Submission on SSD-97528708 - Mixed-use development with in-fill affordable housing at 160 Oxford Street, Paddington

I am writing to object to State Significant Development Application 97528708 for development of 160 Oxford Street, Paddington and nearby properties.

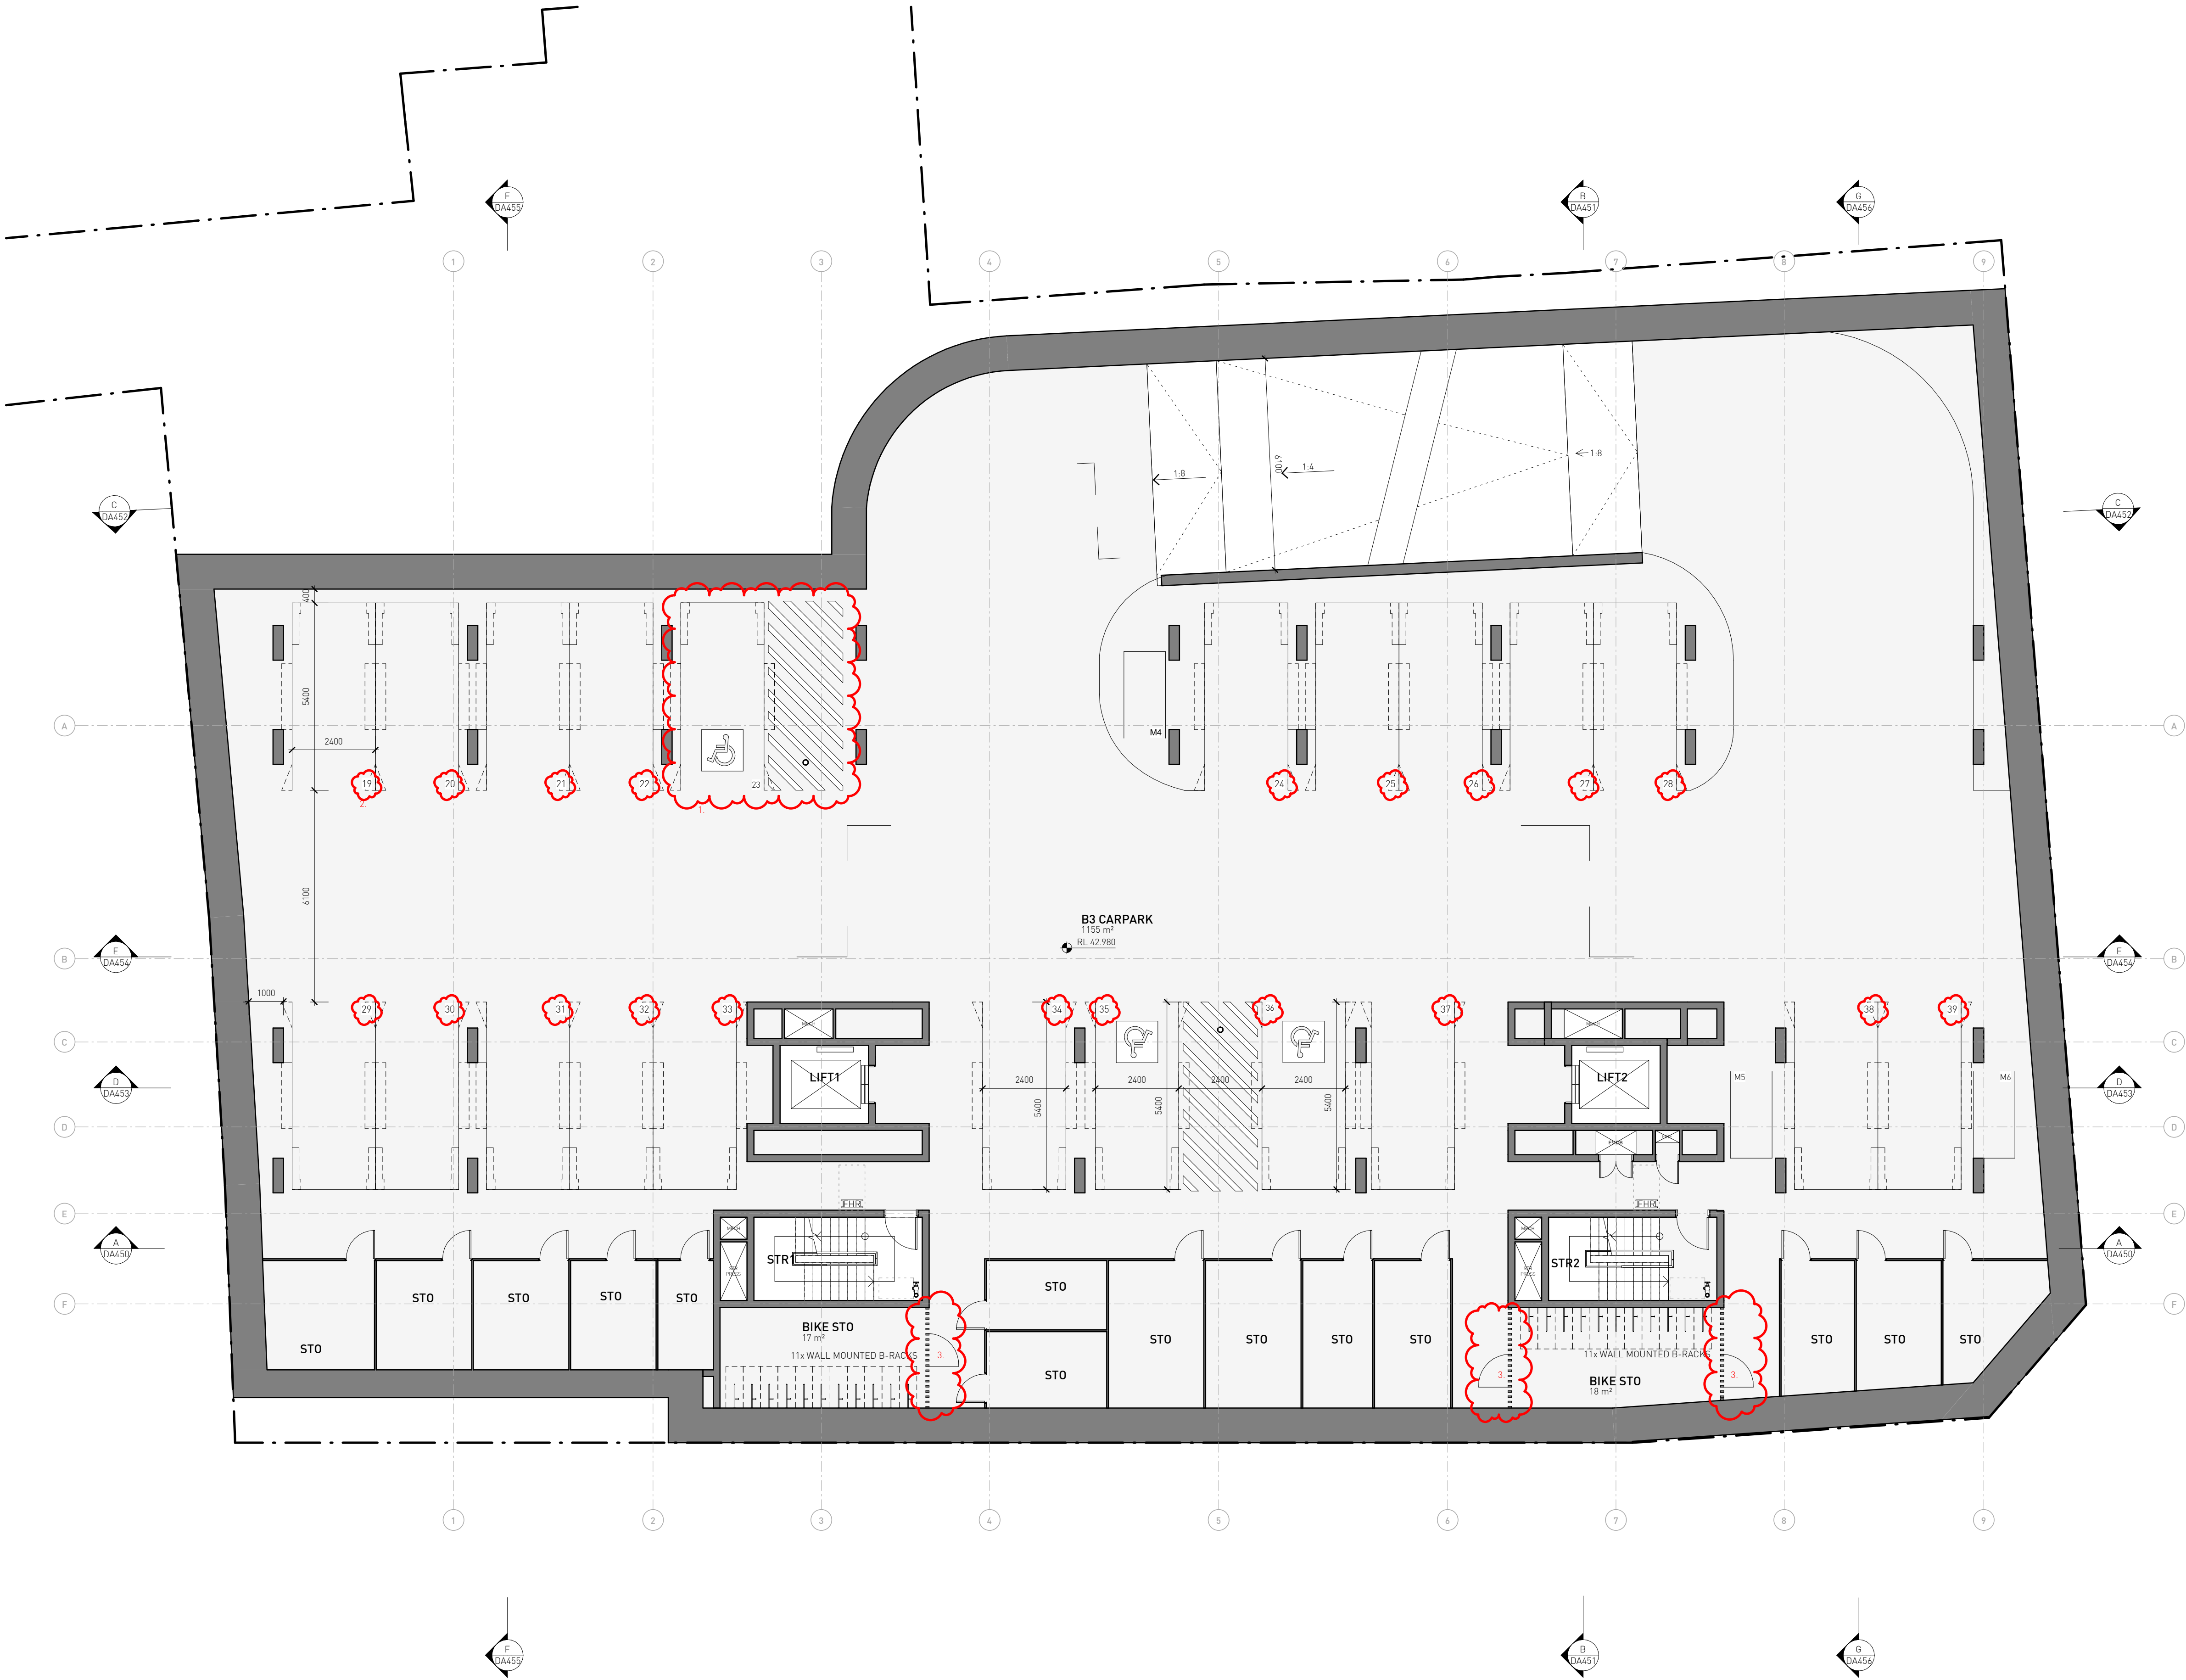
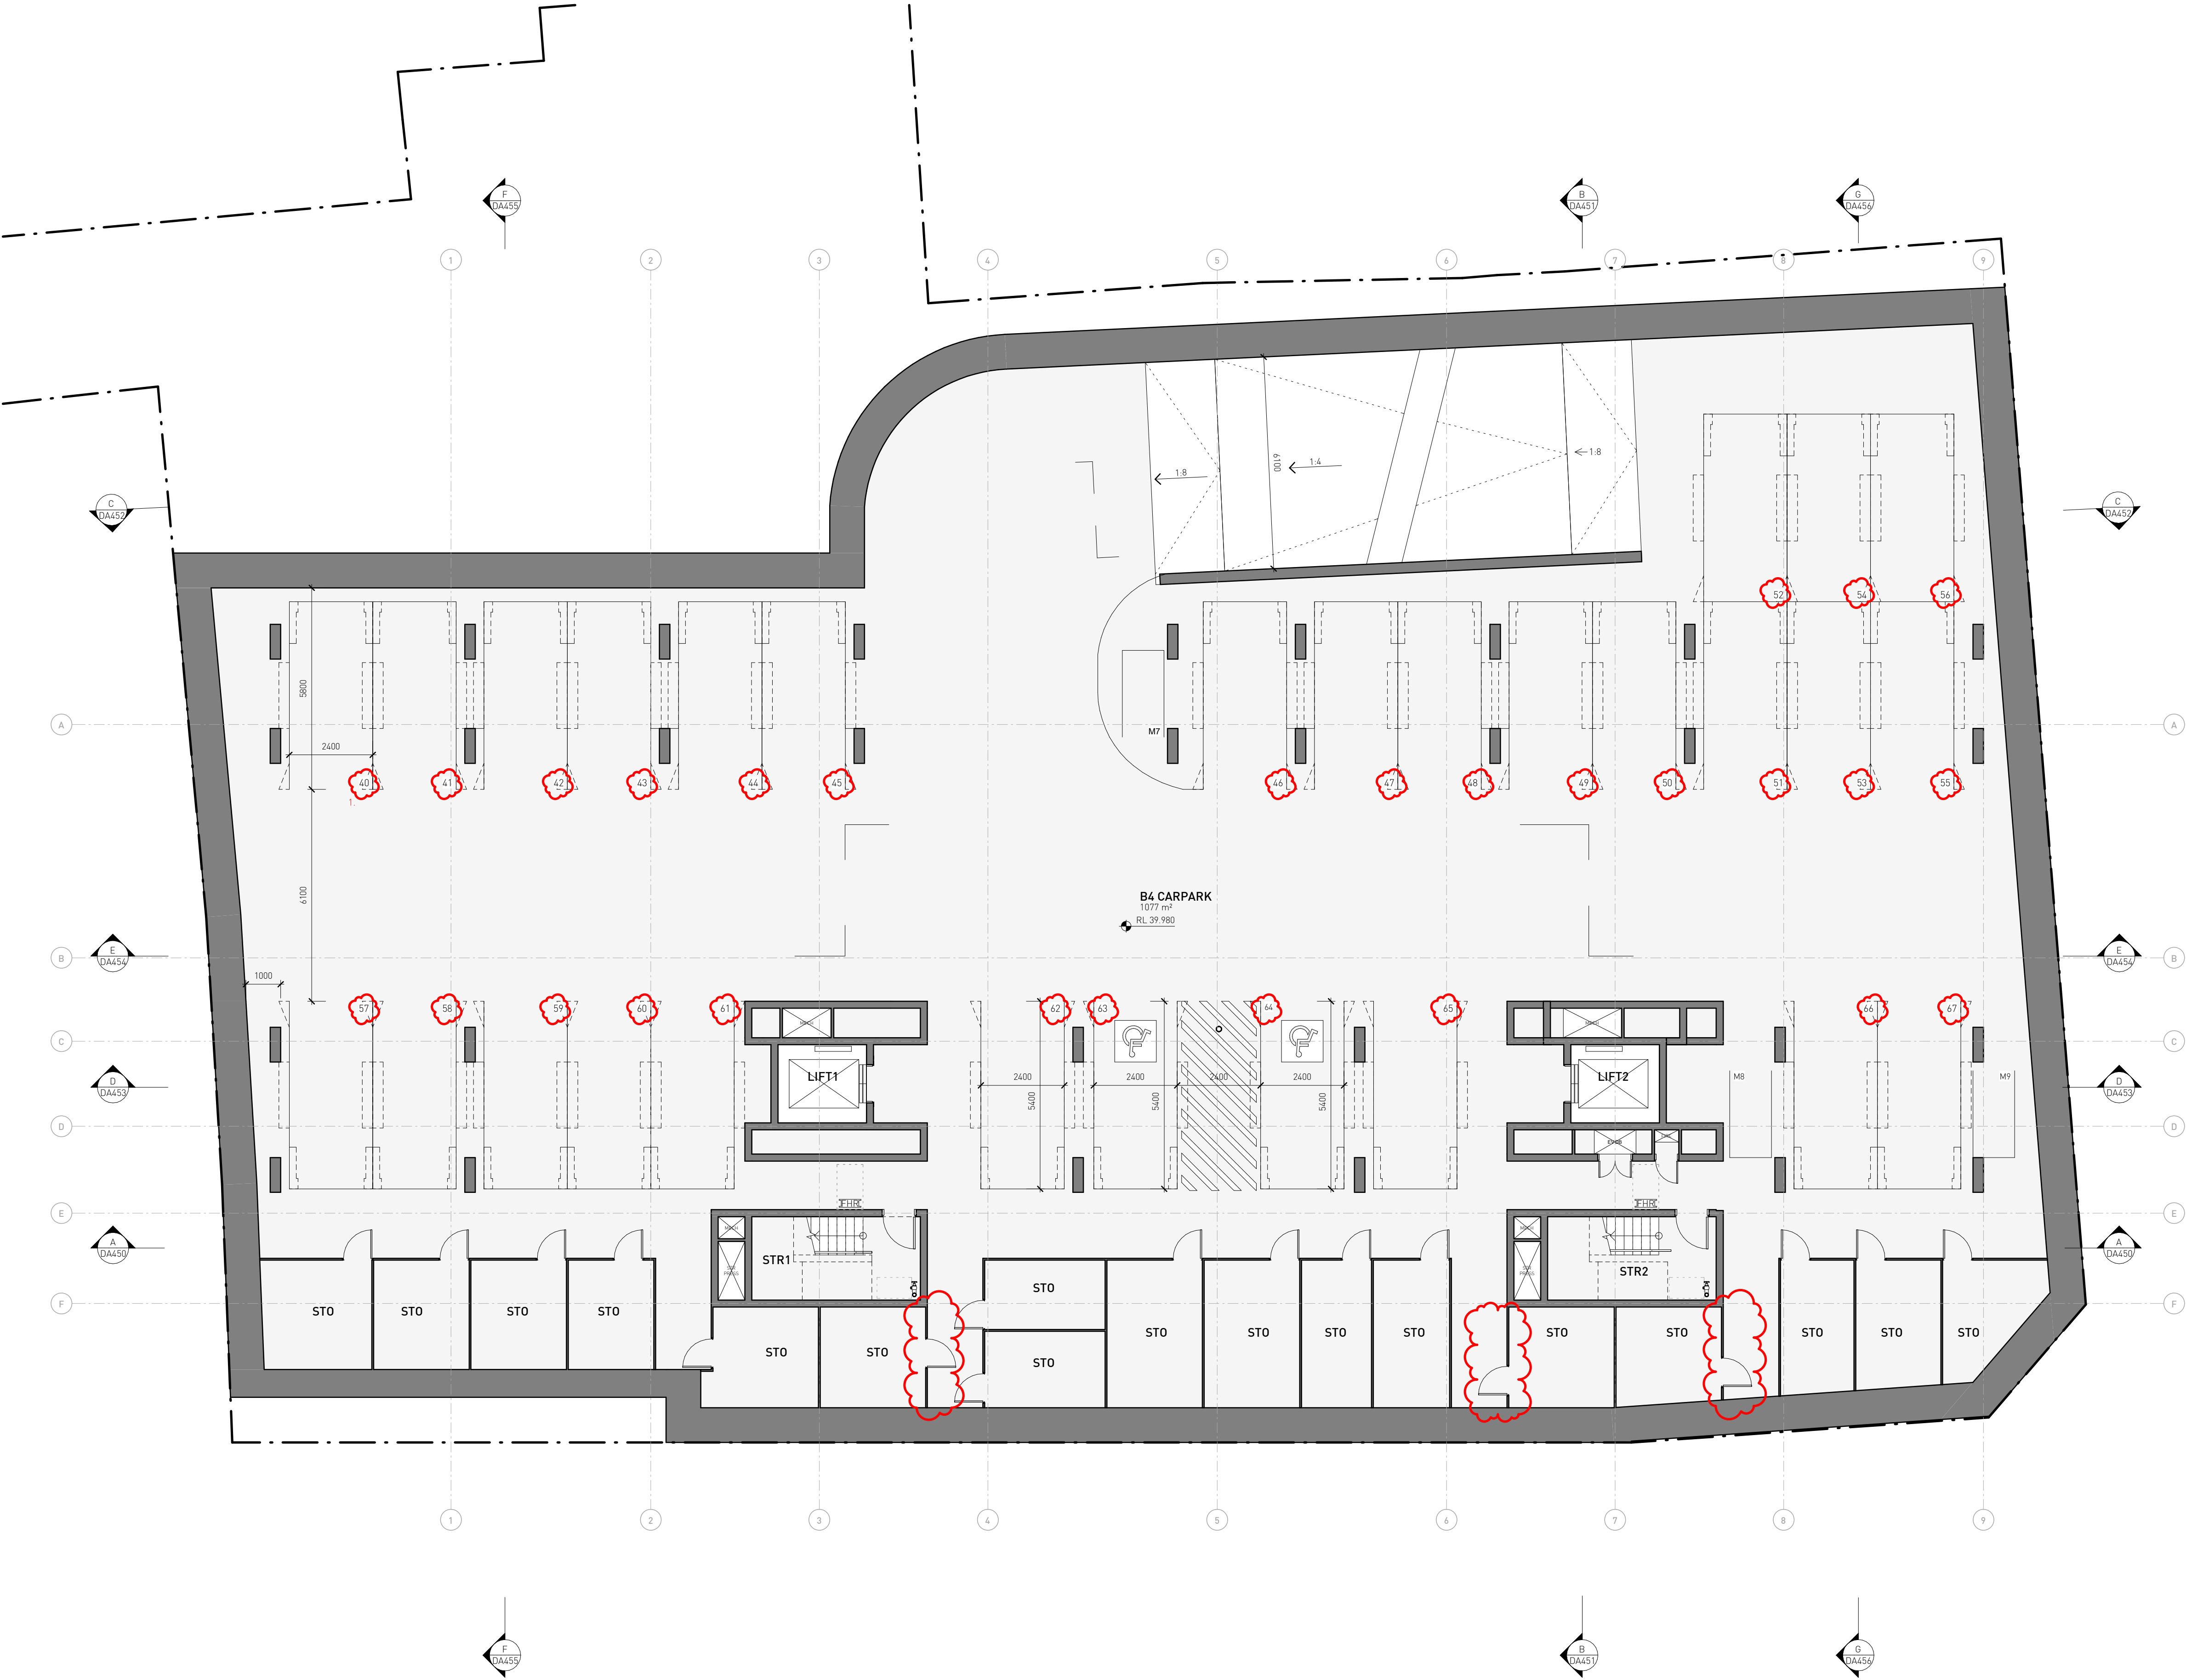
- Very steep ramps between the levels of basement parking (including extensive use of 1:4 grades). In some cases, the claimed grades shown in the architectural plans do not appear to be achievable with the RLs shown in the same plans, e.g. parts of the descent to Basement Level 1. In other cases, the ability to provide the claimed grades cannot be determined accurately as the plans are not fully dimensioned, e.g. the descent from Basement Level 1 to Basement Level 2 and subsequently. The applicant may be seeking to avoid even deeper parking. However, this may not be possible especially as the site drops steeply (3.9m) from the north-east corner on Shadforth Street to the south-west corner on Oxford Street.

- The architectural plans appear to provide five retail spaces, whereas the applicant’s traffic and transport report claims that six spaces will be provided

- The layout is such that it would be difficult for vehicles to get in/out of some spaces, especially but not only the ‘double-stacked’ spaces proposed for Basement Level 4

- Potential issues regarding the clearance (probably around 2.7m) between finished floor levels and the underside of the slabs overhead and any services suspended off the slab above. This may limit the size of vehicles that can use the car park.
